CITY OF PORTLAND BUILDING PERMIT

PERMIT ID: 2013-00492

has permission to **Construct walls per plan; 2nd floor.**

Location of Construction: 75 MARKET ST	Owner Name: WHOLLY COW LLC	Owner Address: 100 COMMERCIAL ST	Phone:
Business Name: Northern New England Housing Inv	Contractor Name: Monaghan Woodworks Inc.	Contractor Address: 100 Commercial St. Portland	Phone (207) 775-2683
Lessee/Buyer's Name	Phone:	Permit Type: Alterations - Commercial

A1.2

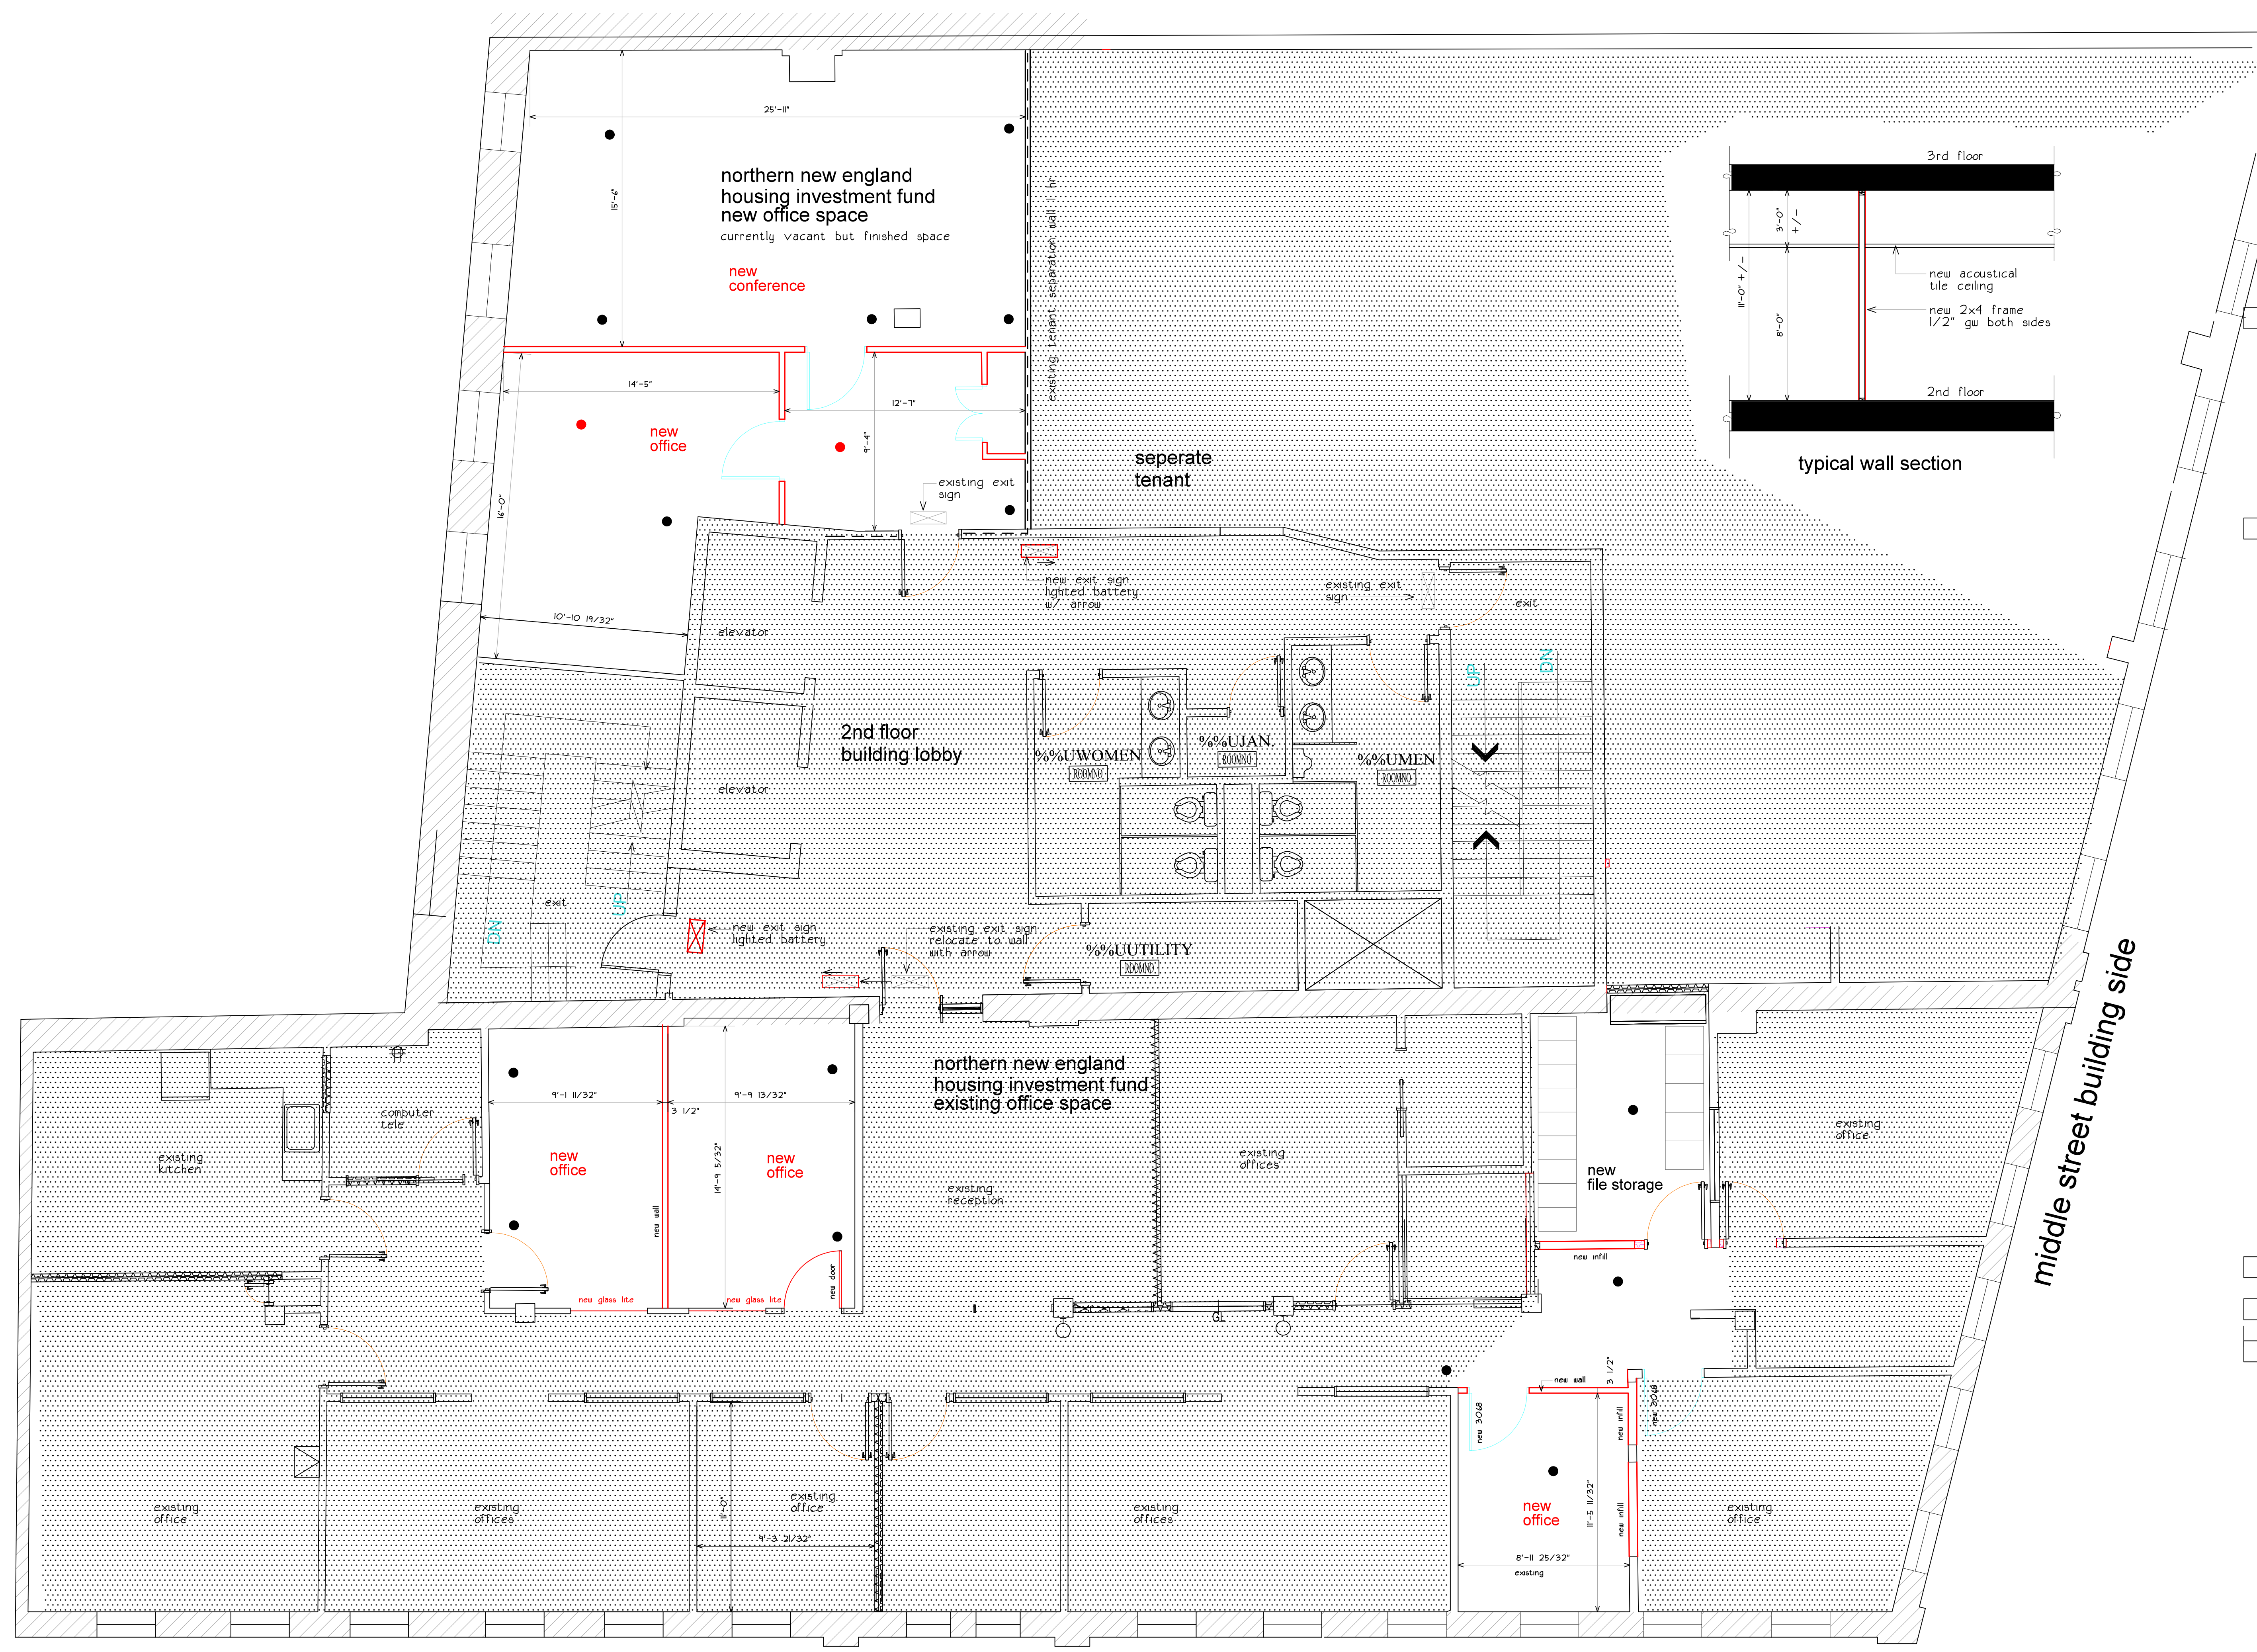
Dept: Building	Status: Approved w/Conditions	Reviewer: Tammy Munson	Approval Date: 04/16/2013
Note:	Ok to Issue: <input type="checkbox"/>		
<ol style="list-style-type: none"> 1) All wiring must be non-combustible material. 2) All framing must be non-combustible framing. 3) Separate permits are required for any electrical, plumbing, sprinkler, fire alarm, HVAC systems, heating appliances, including pellet/wood stoves, commercial hood exhaust systems and fuel tanks. Separate plans may need to be submitted for approval as a part of this process. 4) Permit approved based upon information provided by the applicant or design professional. Any deviation from approved plans requires separate review and approval prior to work.
